PLANNING & COMMUNITY DEVELOPMENT

Date: November 14, 2024

Subject: Request for a two-year extension to record the first Final Plat of the Eagle Rising Preliminary Plan (PCD File No. SP205)

EAGLE RISING FILING NO. 1
FINAL PLAT
JOB NO. 43-043
DATE PREPARED: 06/30/2022
DATE REVISED:

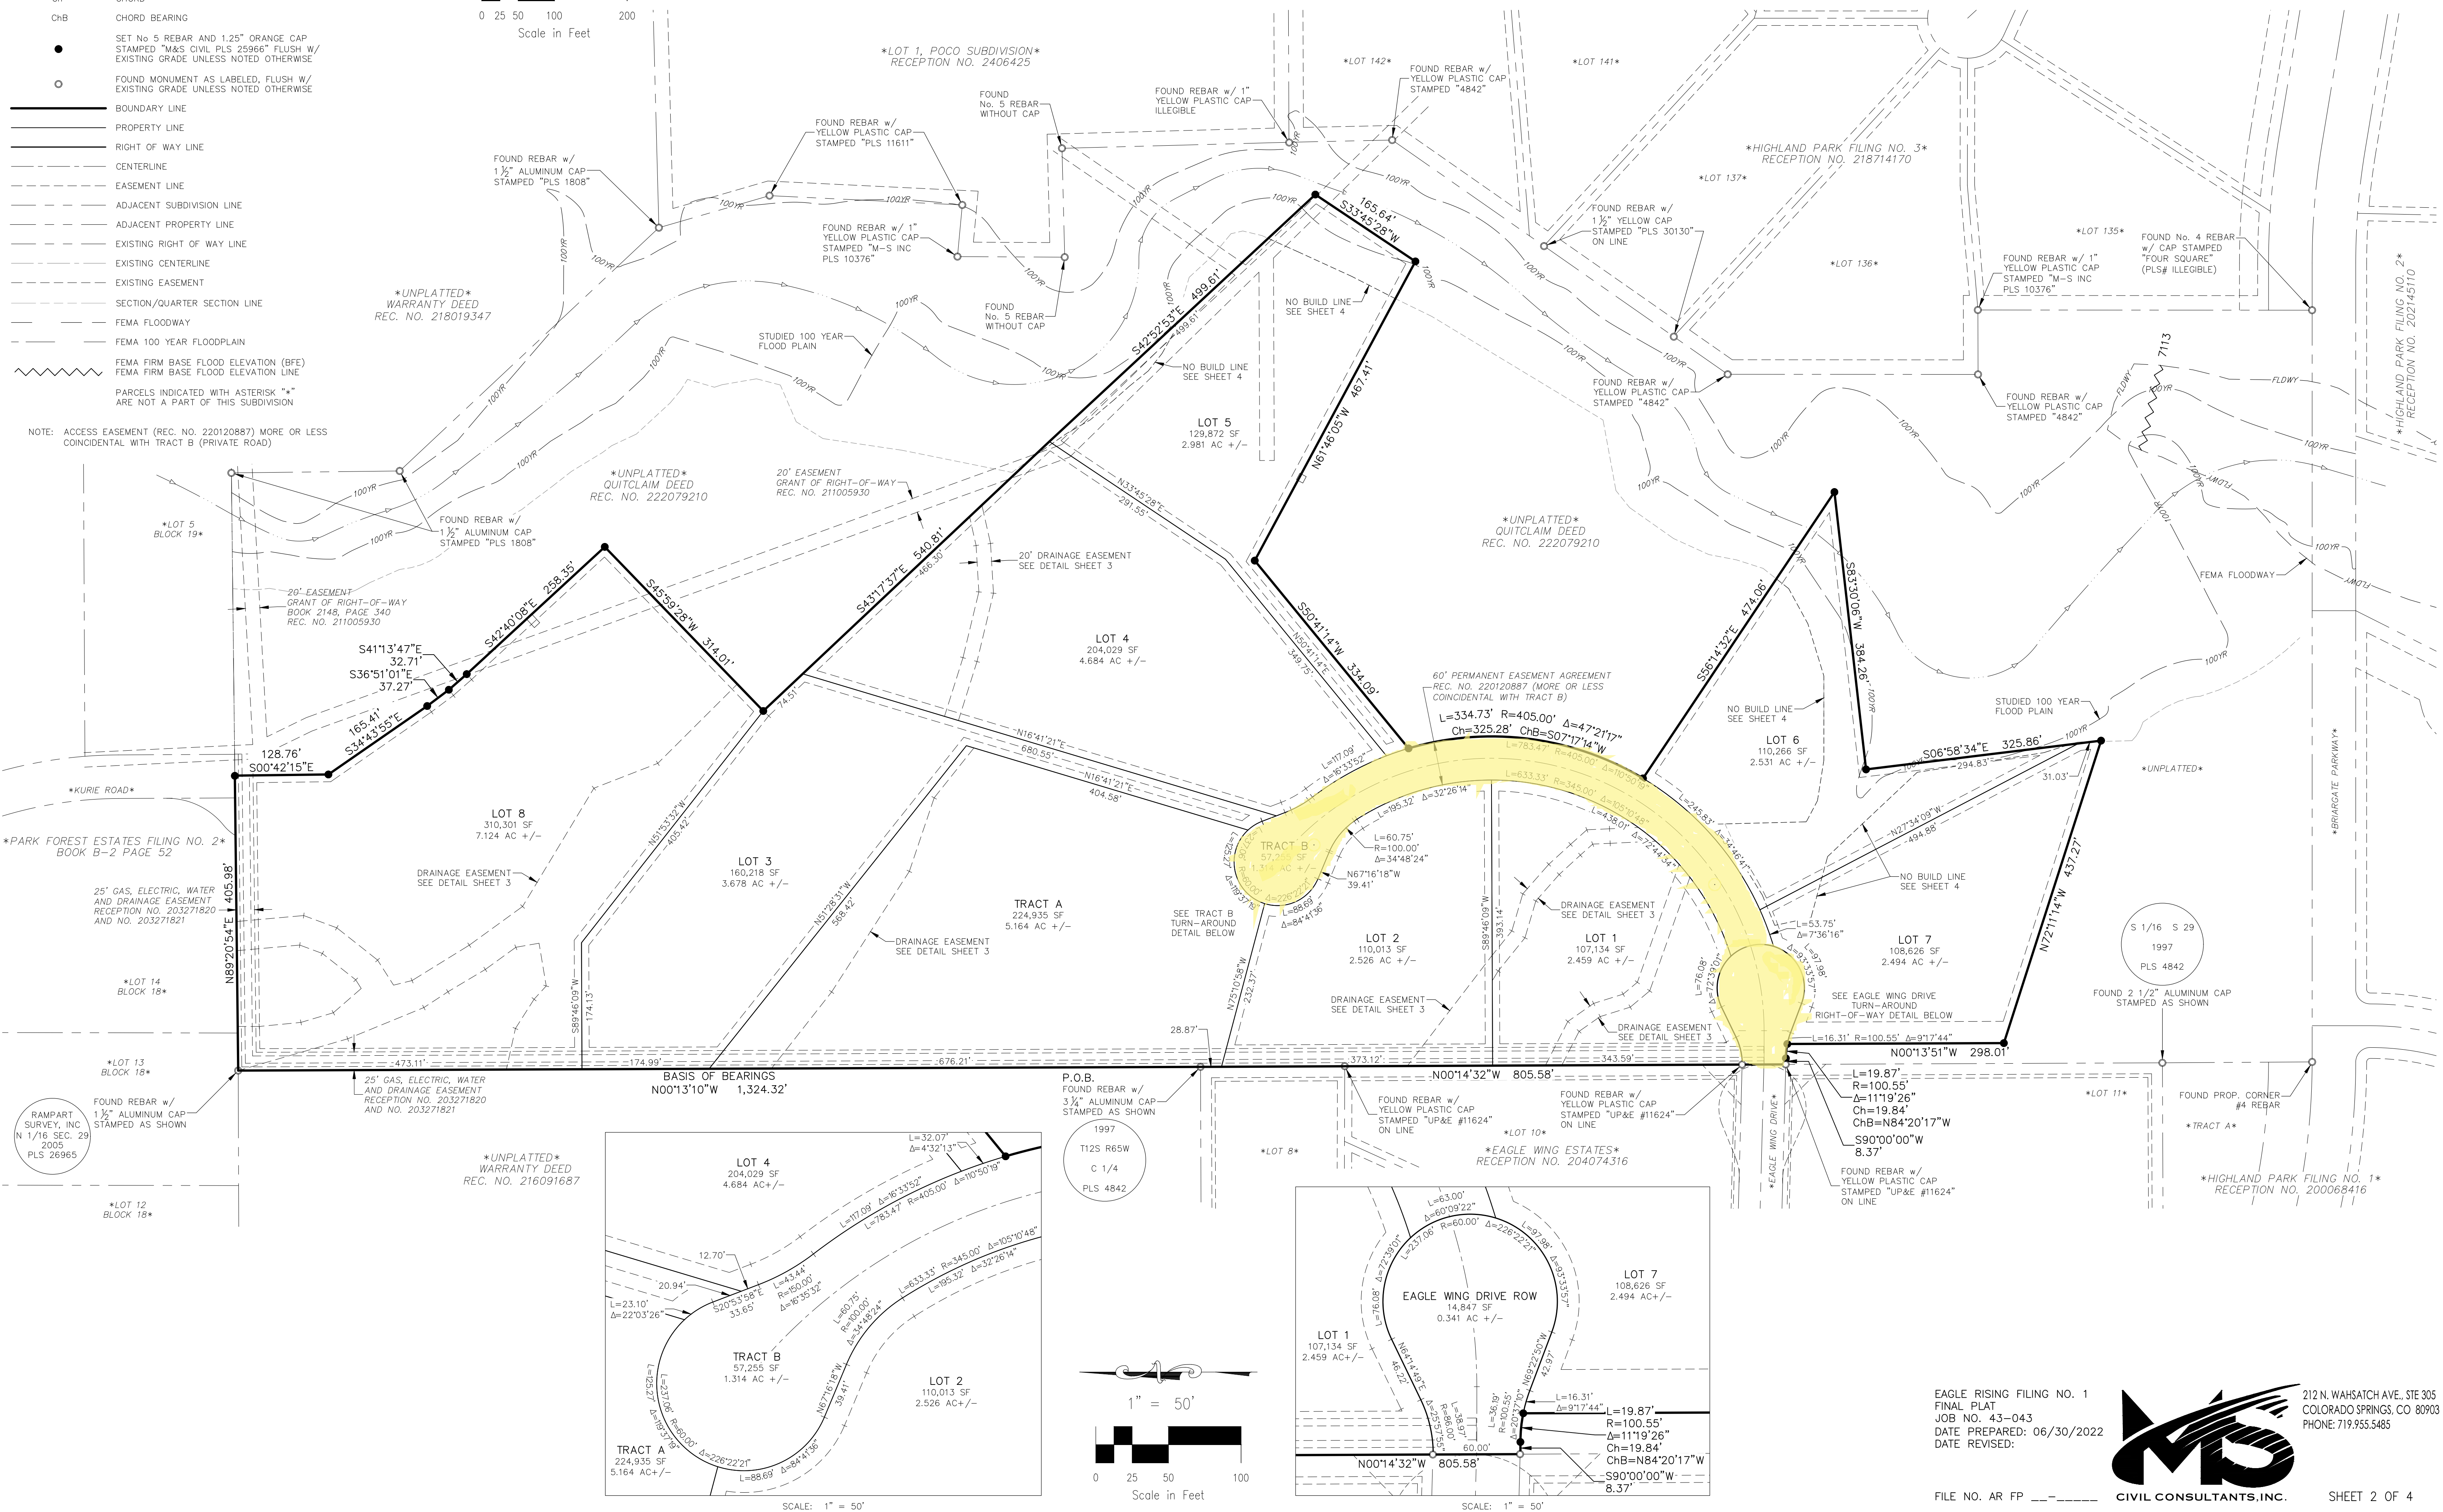
Staff provided initial comments for the Eagle Rising Filing No. 1 Final Plat on September 1, 2022, identifying the need for the depiction of property for right-of-way for the cul-de-sac extension of Kurie Road (the "Kurie Road Extension") on the Final Plat in order to ensure conformance with the Preliminary Plan. Staff most recently provided review comments on October 3, 2024, with the Kurie Road extension remaining an outstanding issue; a resubmittal has not yet been received to address these comments.

Staff has determined that the proposed Final Plat which subdivides property over the approved cul-de-sac configuration is not in substantial conformance with the approved Preliminary Plan.

Staff has determined that this Code section cannot be met by the Final Plat without the depiction of and dedication of the appropriate land area for the necessary right-of-way, and the proposed condition of approval will ensure compliance with this Section of the Land Development Code.

To assure compliance with note 4 on the Preliminary Plan, each Final Plat that includes property shown as right-of-way for the cul-de-sac extension of Kurie Road (the "Kurie Road Extension") shall dedicate such right-of-way to El Paso County for public road purposes at the time of platting.
